Ref 2312.corr.RVBC241025

**2312 Springs Barn, Old Nab Road, Langho, Blackburn, BB6 8DY**

This application follows a previous planning application ref.3/2024/0355 for a flat roof extension to the existing dwelling that was refused. Following the refusal, Stanton Andrews have engaged in informal discussions with the planning officer, Kathryn Hughes, to develop a scheme that suits the applicant's brief that would be agreeable to the local authority.

project springs barn 23.12
name plans
scale 1 to 100 @ A1 date october 2024 note planning revision A

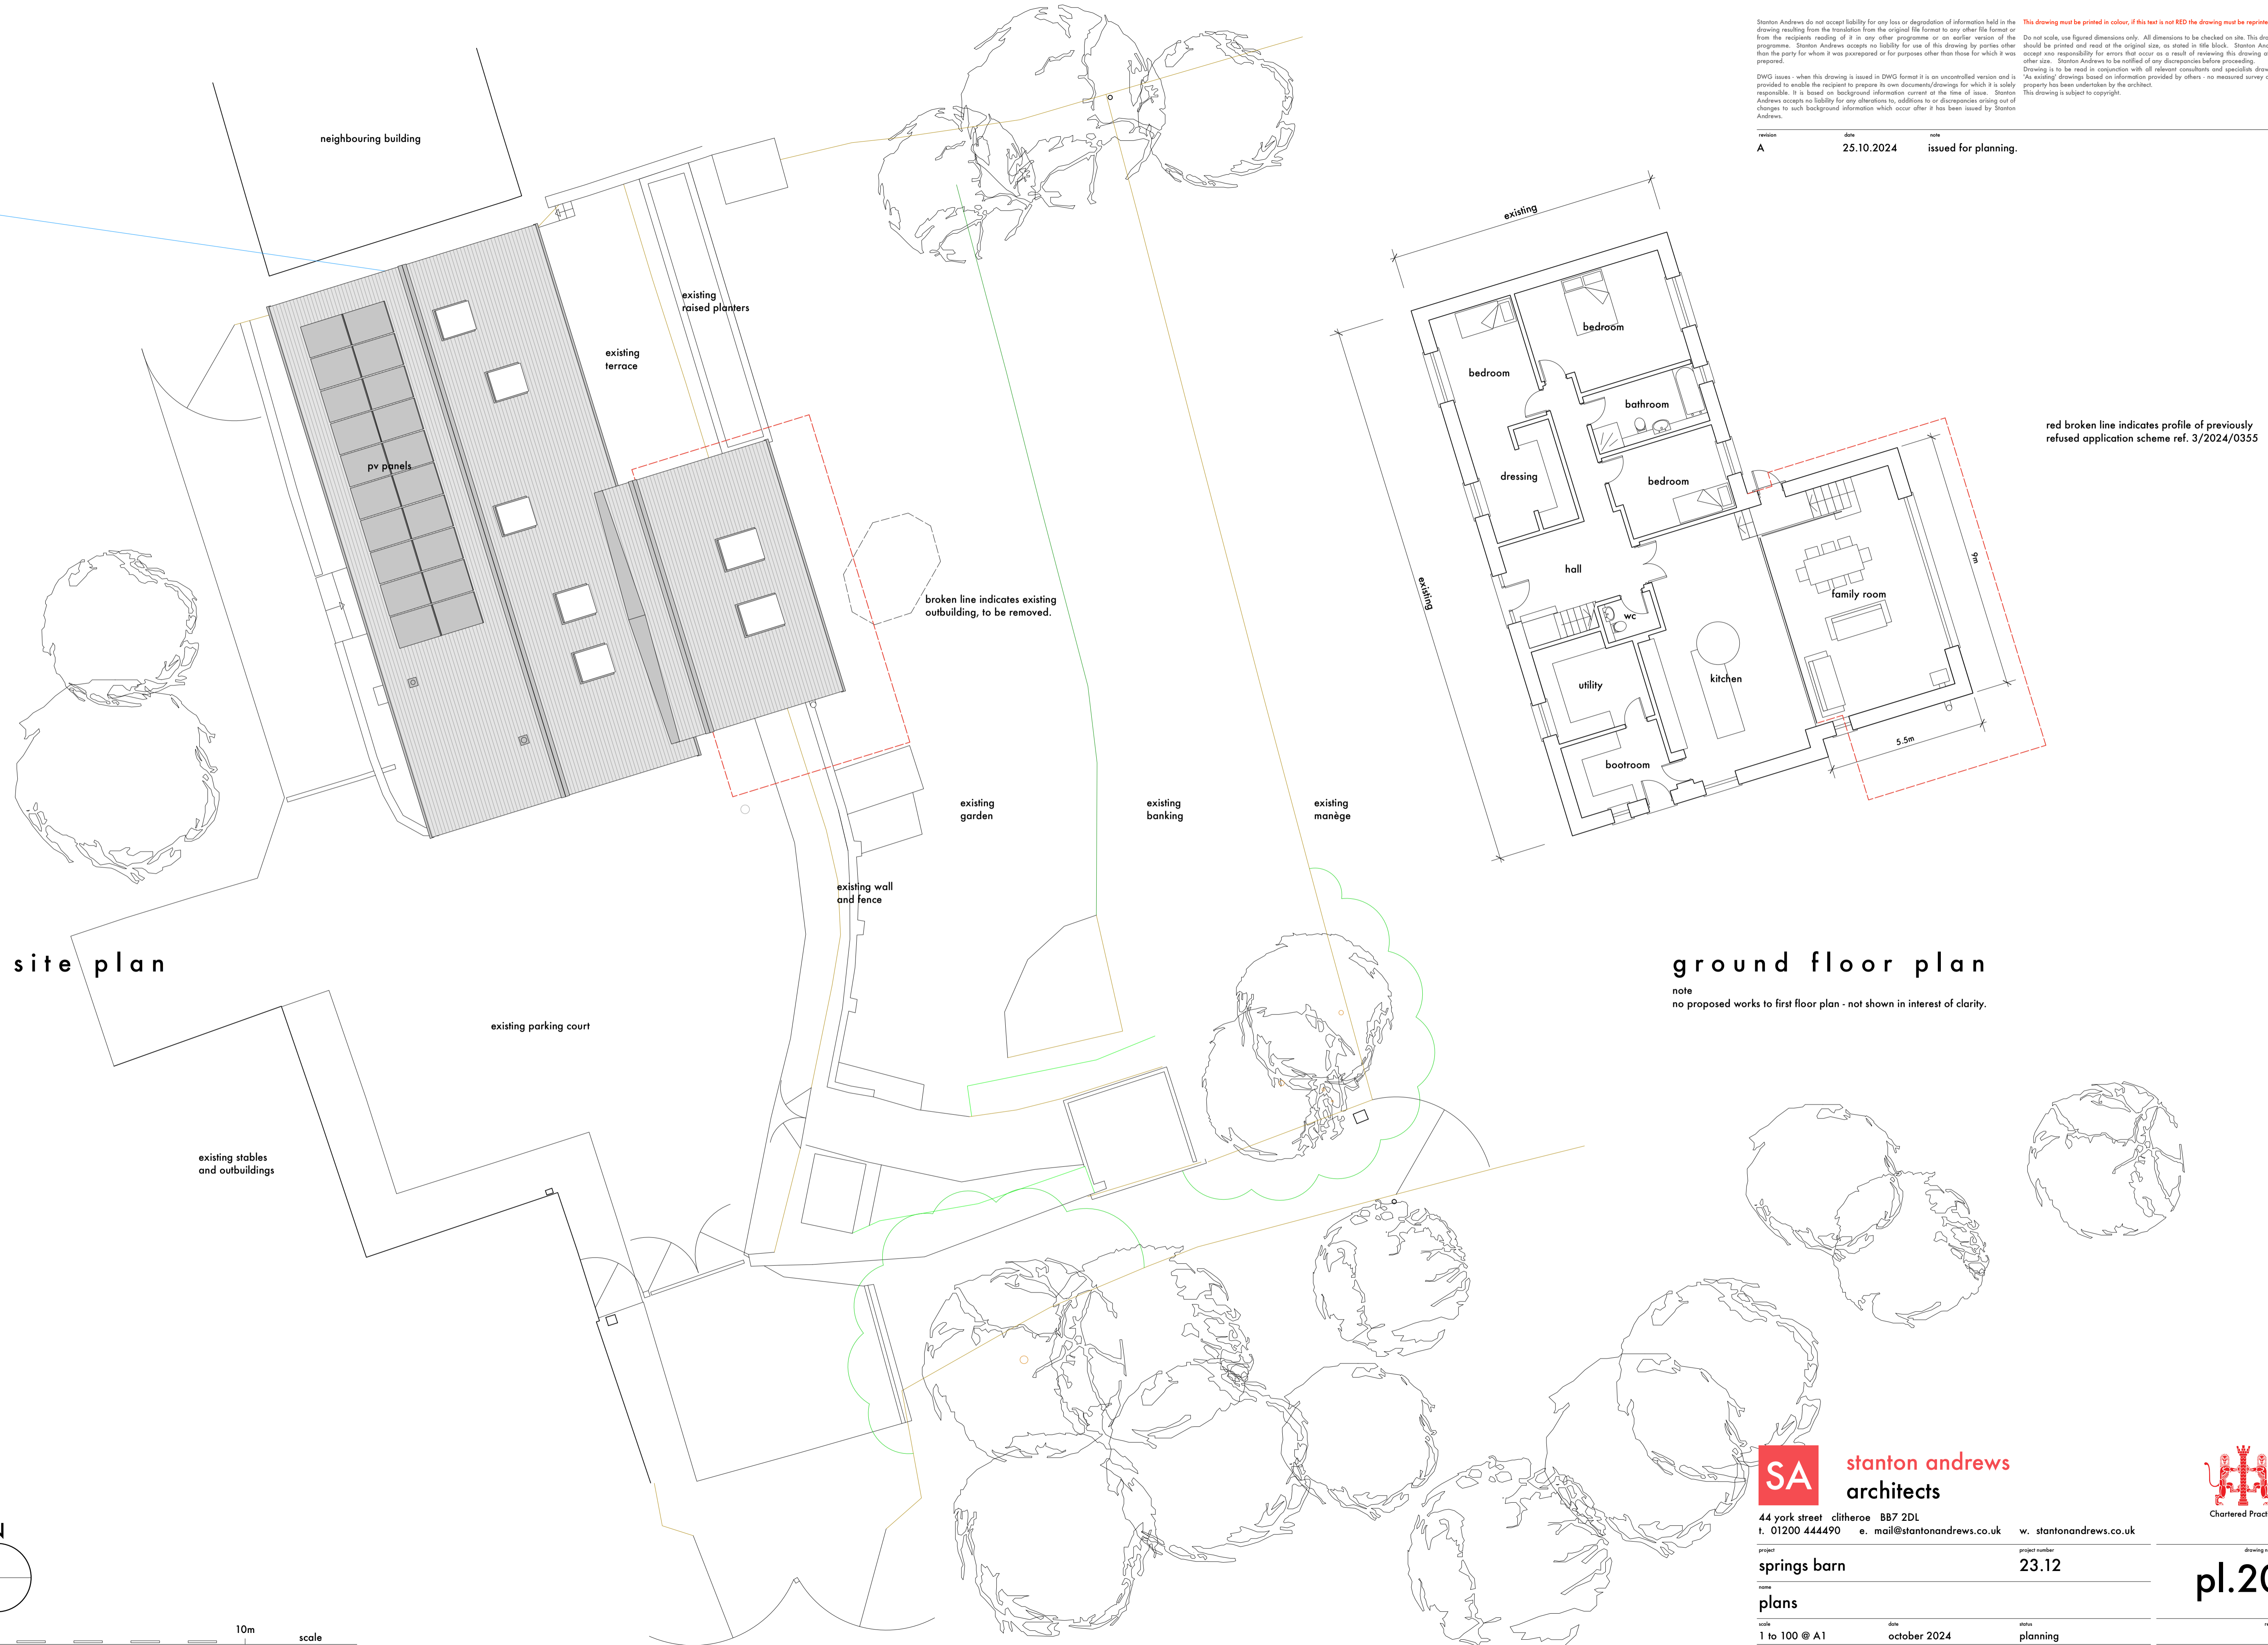
1. *Impact on the Openness of the Green Belt*  
*'The proposed extension would result in an increase in volume of around 30% which in itself would be considered an acceptable addition in terms of volume alone. However, the overall scale and massing of the extension together with its siting are considered to fail to protect the openness of the Green Belt.'*

The proposed extension has been repositioned, set back from the southern gable of the existing dwelling. Following discussions with Kathryn Hughes, this is deemed to be acceptable.
